NORFOLK BOREAS

Oulton Parish Council's response at deadline 6 to the Applicant's response to written questions at deadline 5

© Vattenfall Wind Power Ltd 2019. Contains Ordnance Survey data
© Crown copyright and database rights 2019 Ordnance Survey 0100031673

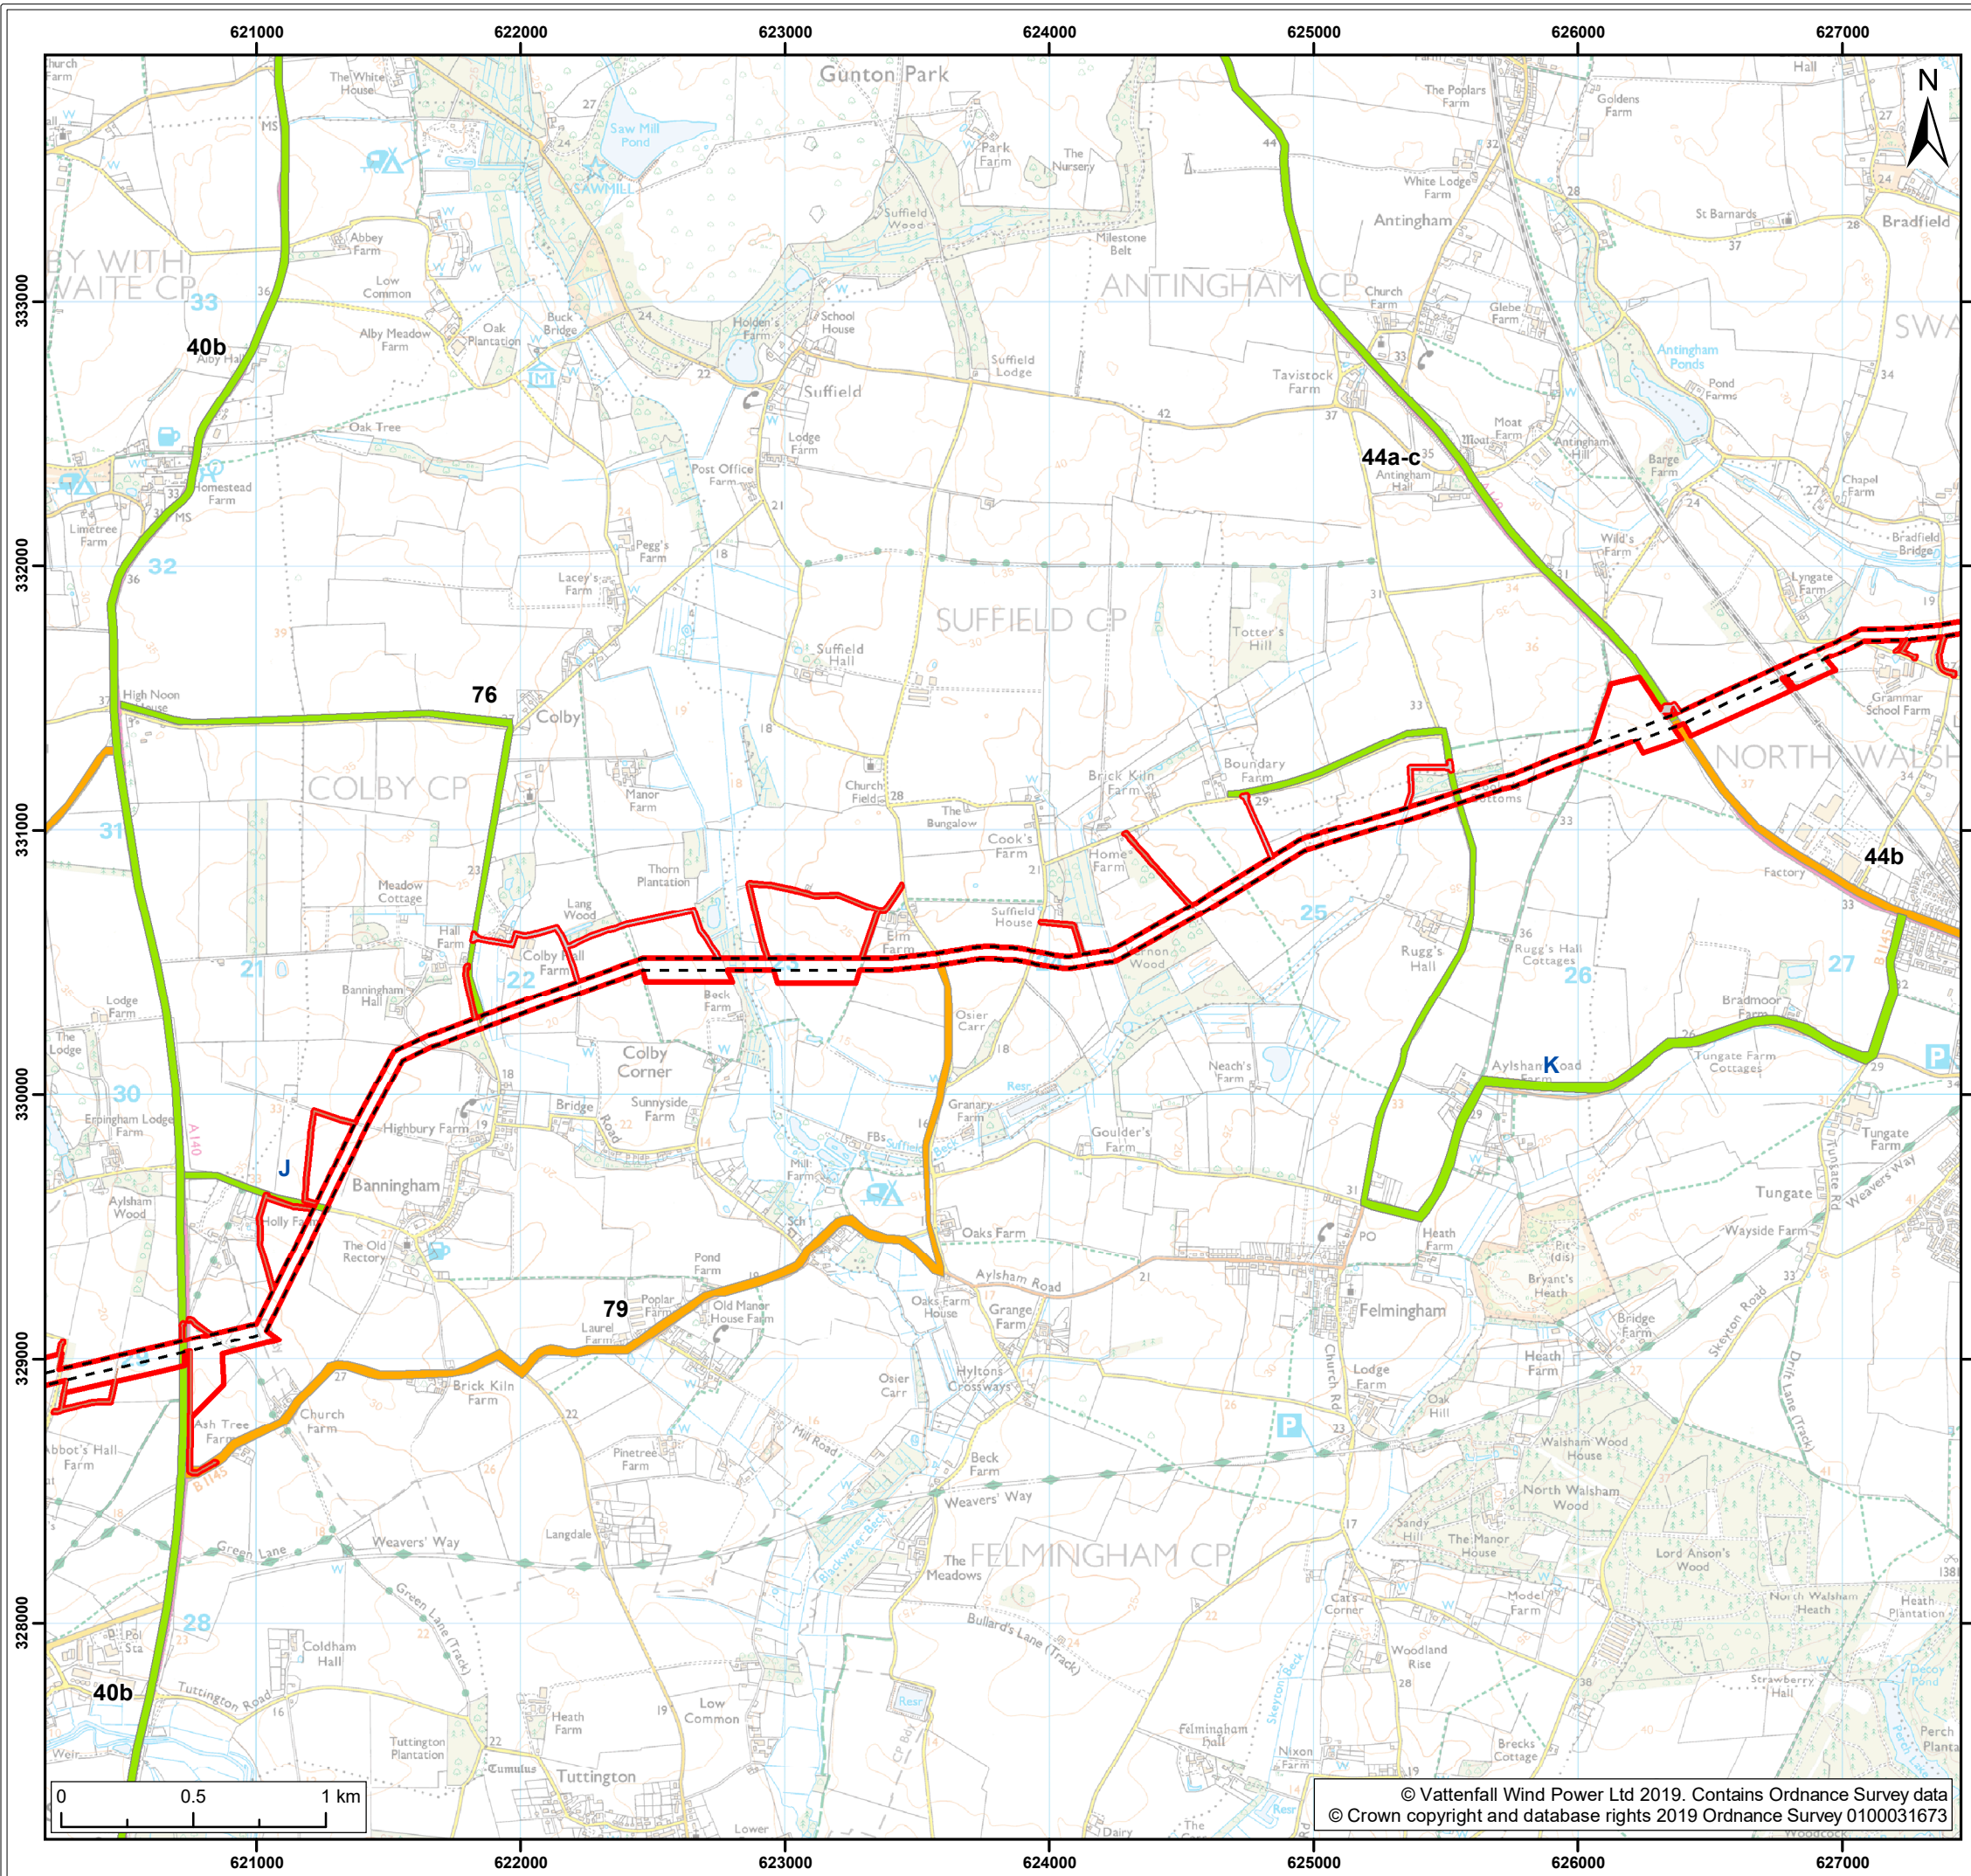
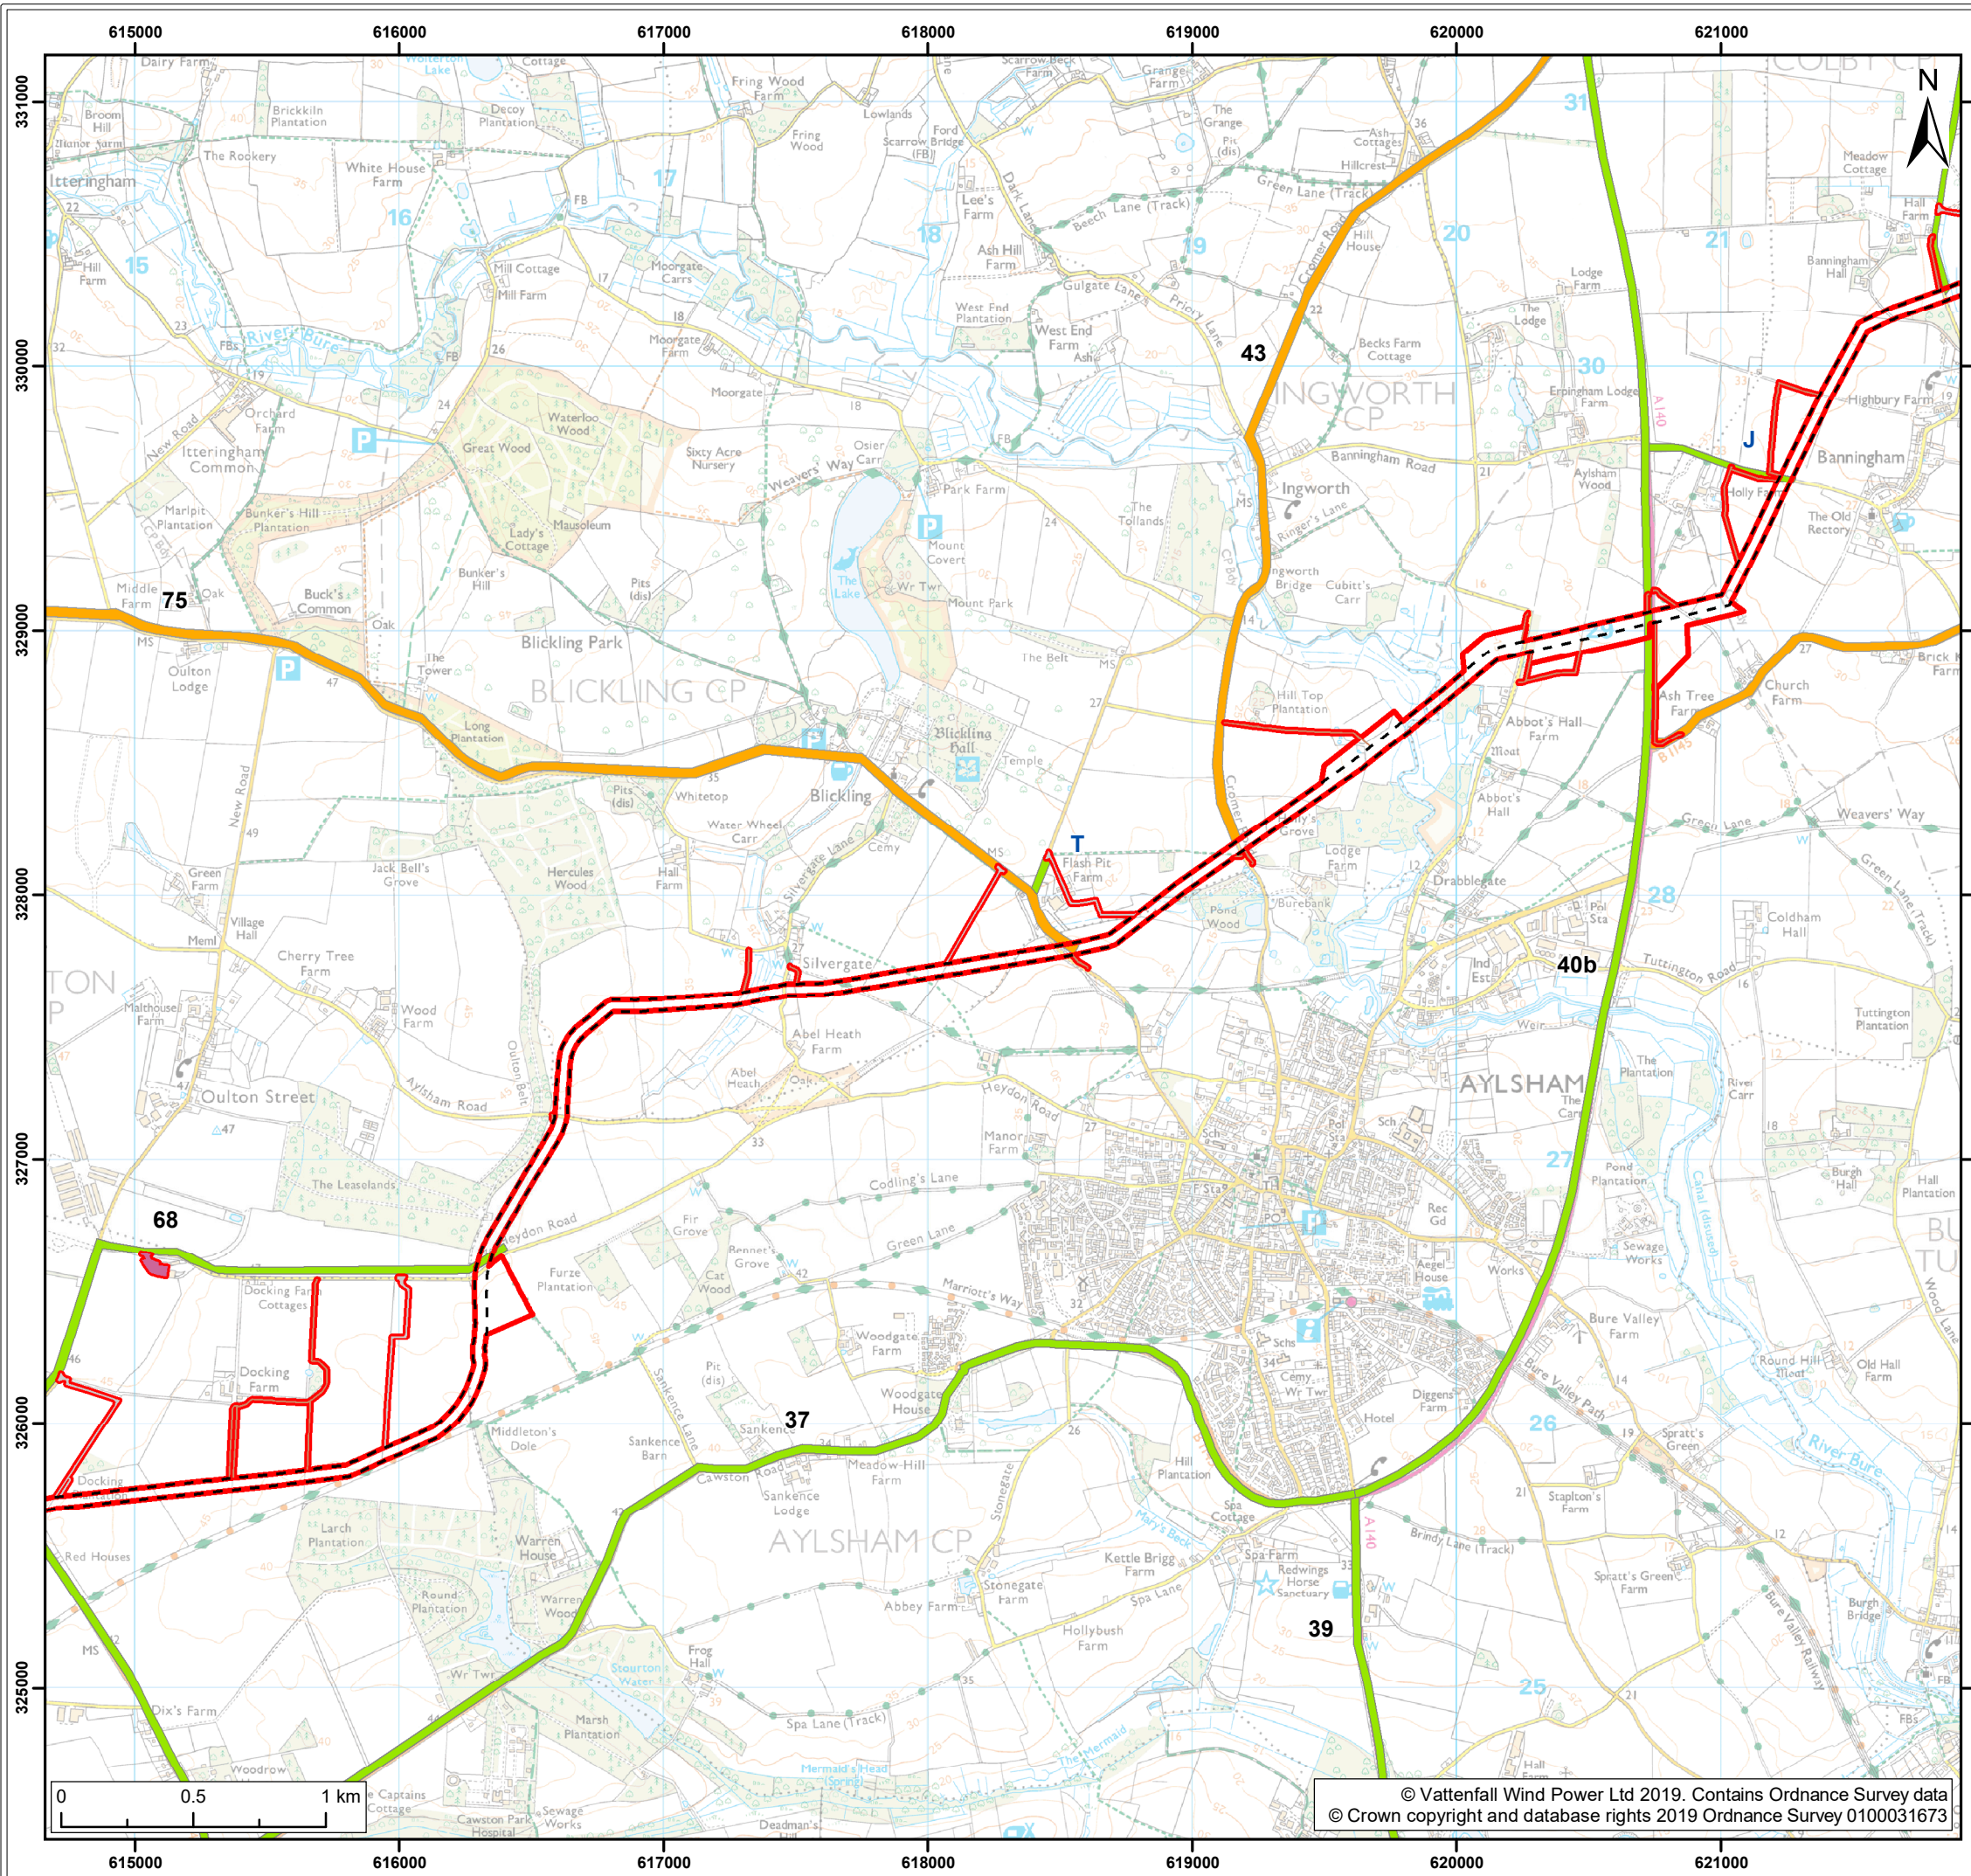
The assessment established that Link 68 has no national, regional or local designation as a cycle route/walking route and therefore is not a sensitive link with respect to those user groups. Therefore, the mitigation proposed for Link 68 was not specific to NMU but developed for all modes. ”

OPC note that the Applicants have dismissed Link 68 as a cycle route, as it is not designated. This is incorrect and extremely misleading. It should be noted that Link 68 is used by many individual cyclists, often by cycling clubs from near and far, doing a circuit from Aylsham or Norwich, and those who wish to join up with the Blickling Cycle route, along with Itteringham village shop/cafe off Link 75. It is also seen as a “safe” circular route for joggers, families with young children cycling out informally from Aylsham - across Abel Heath, along Heydon Road, up Oulton Street and back via Aylsham Road.

In fact, there are 3 designated cycle routes (figure1-3) that pass either along or near Oulton Street.
